**DEVIATION REVIEW
 AND DECISION FORM**

Subdivision or Project Name: Homestead at SR Filing No. 2

Section of ECM from Which Deviation is Sought: ECM 3.3.1.J.8
 Specific Criteria from Which a Deviation is Sought: Maximum Storm Sewer velocity shall be 18 fps.
 Summary

**STORM 3
STA 1+00.00 TO STA 7+63.63**

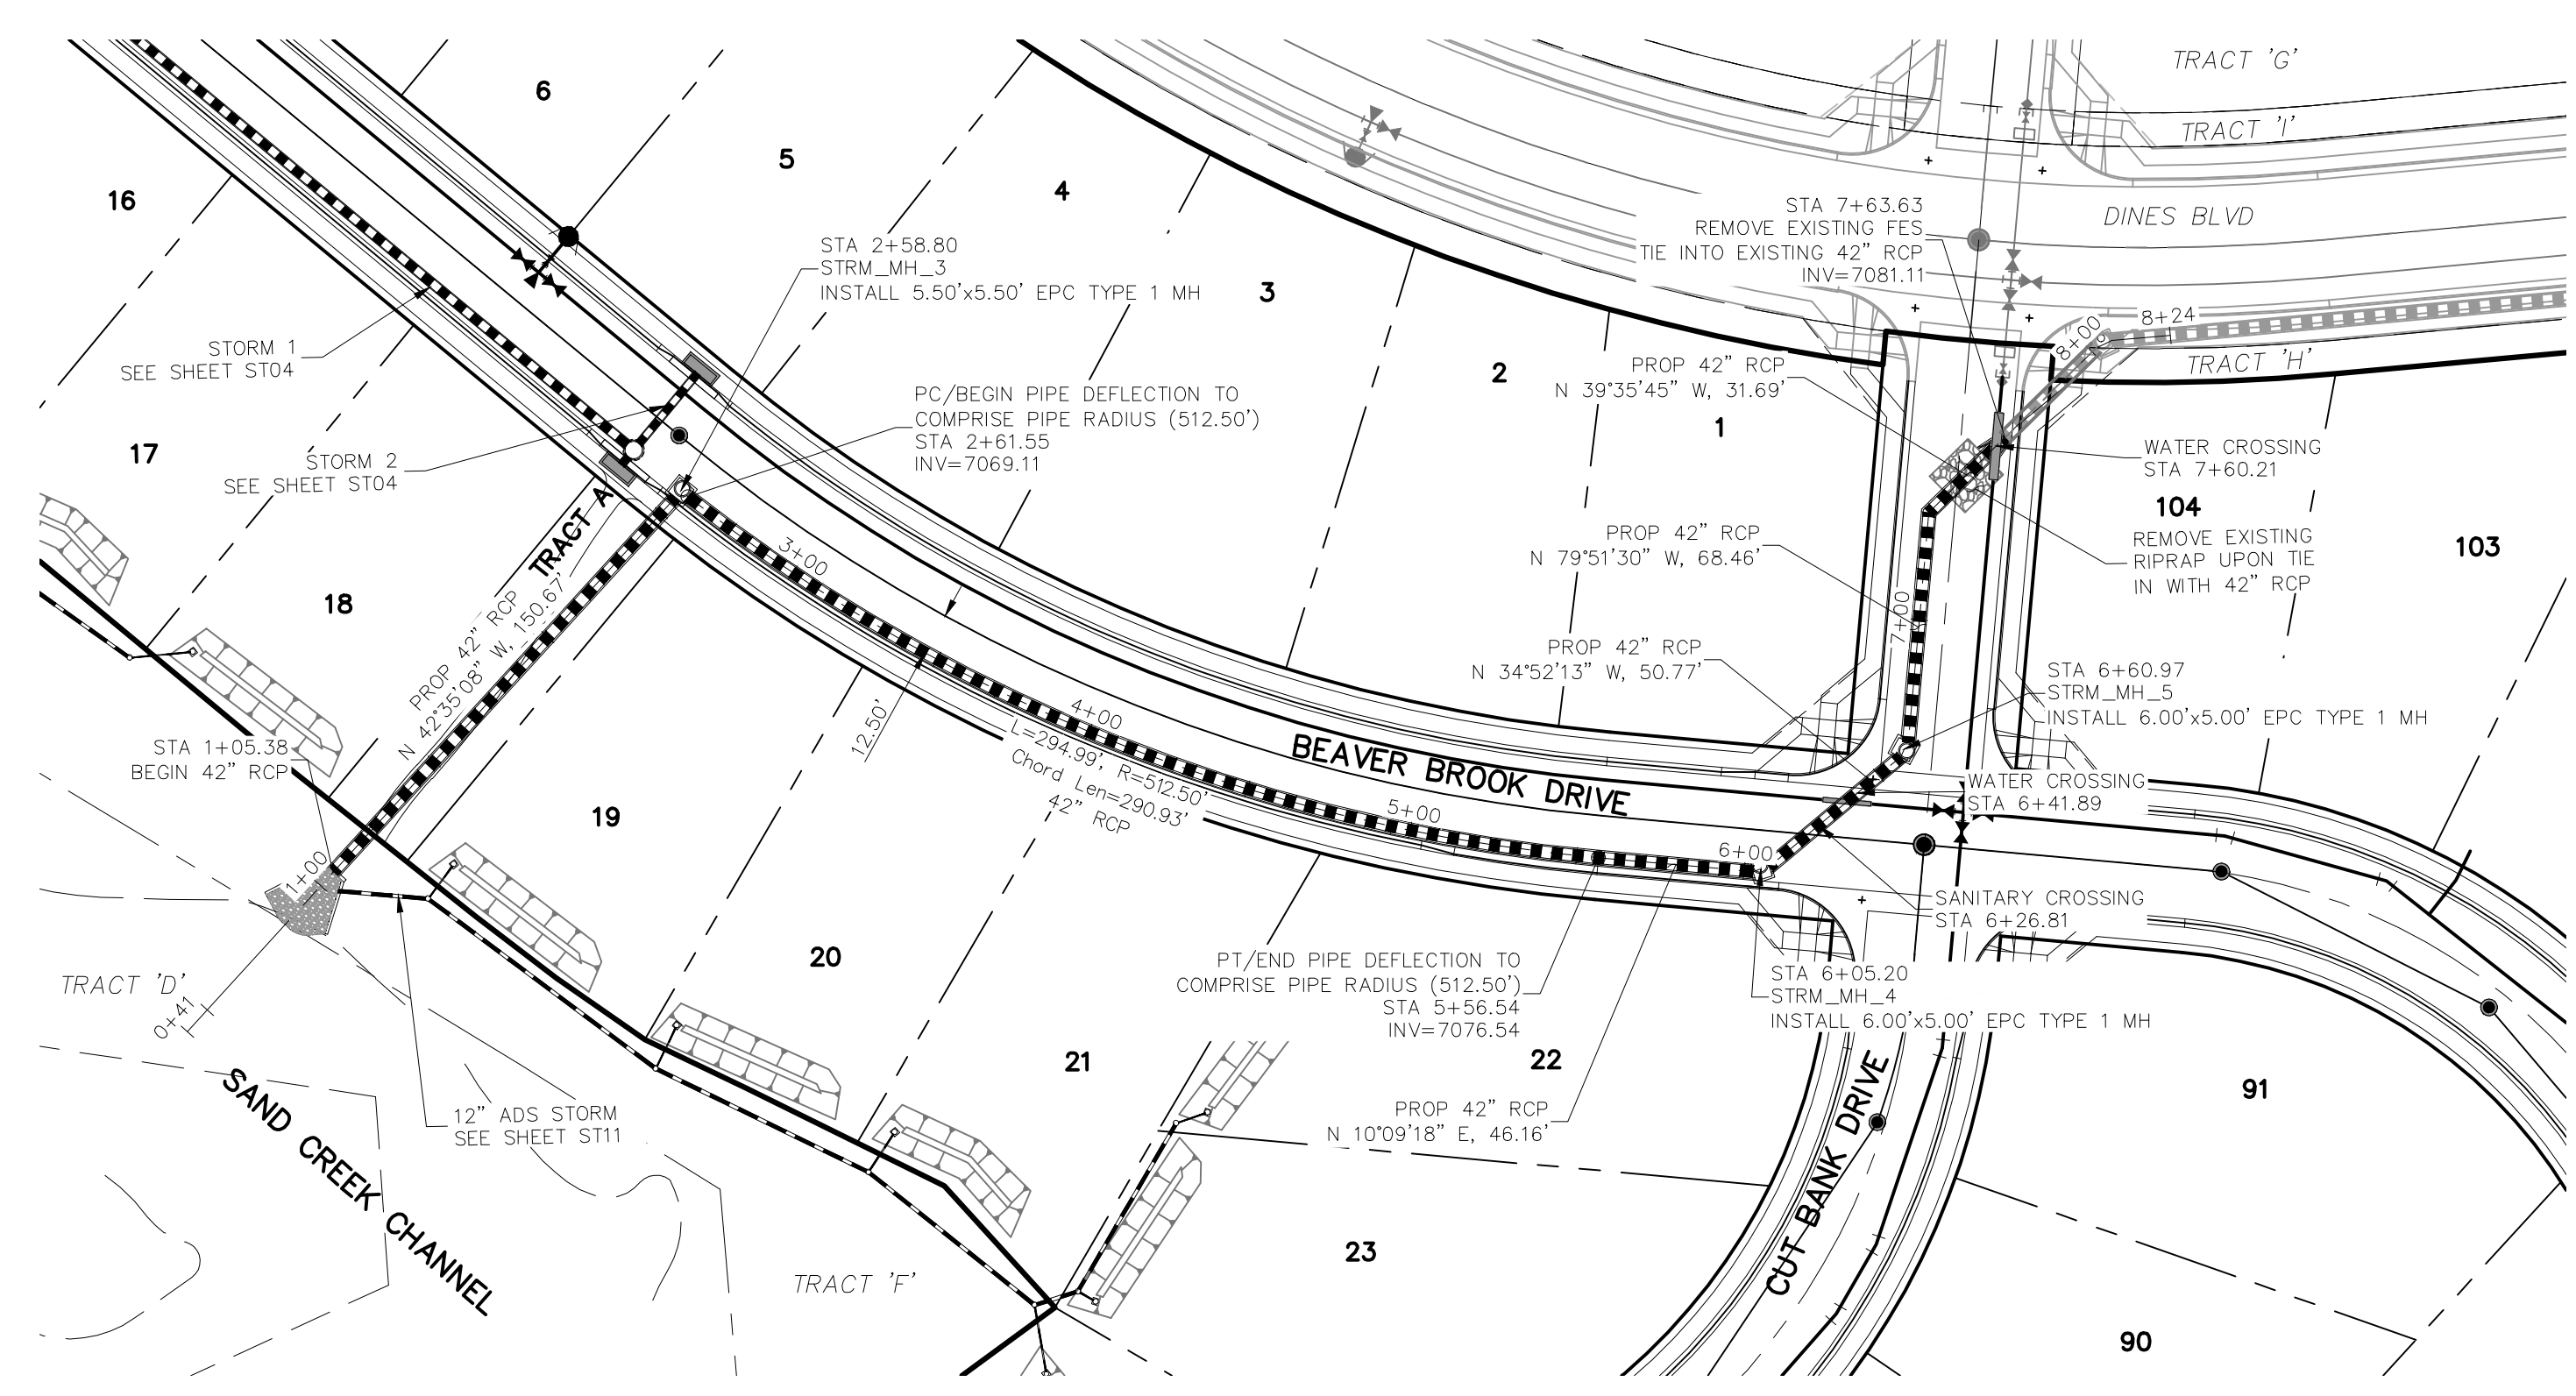
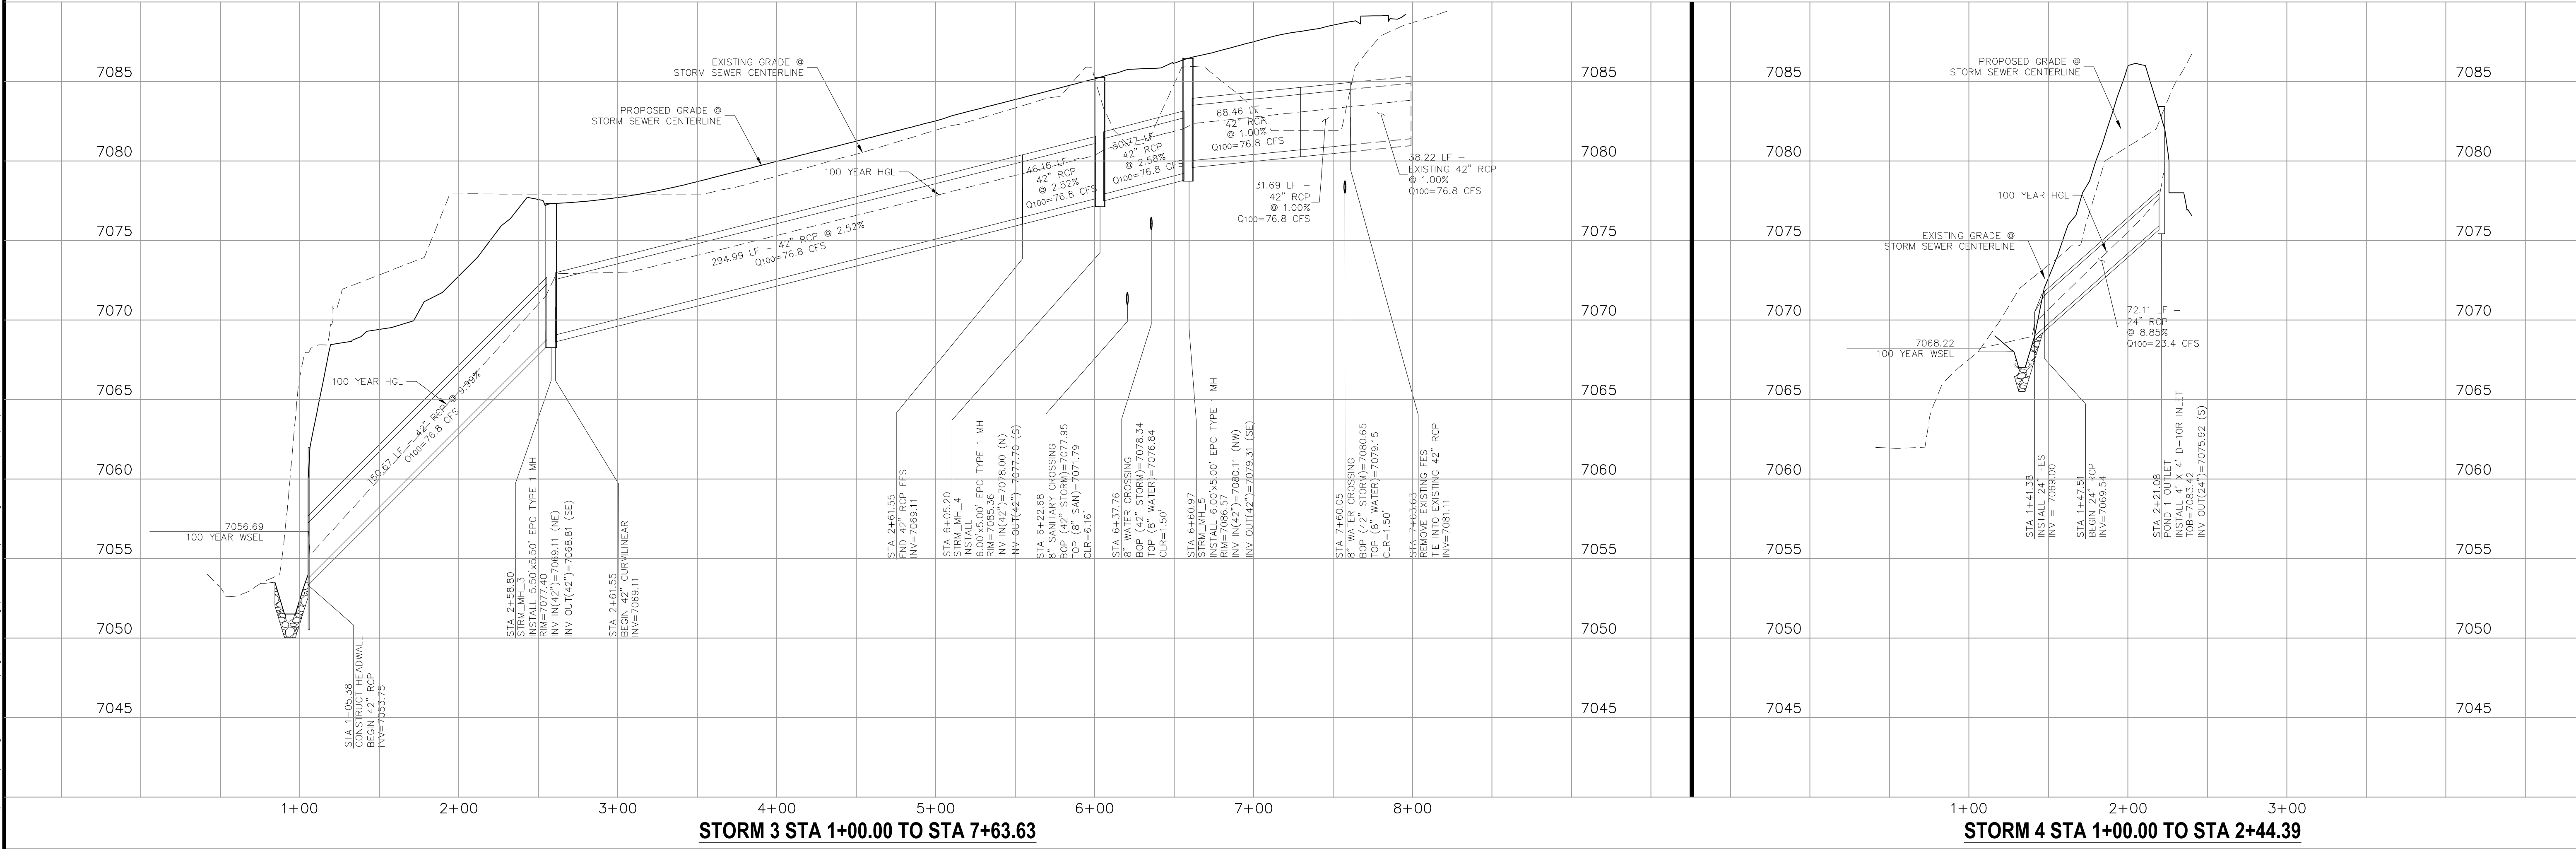
Address the outfall design. What can be done to reduce velocities at the outfall?
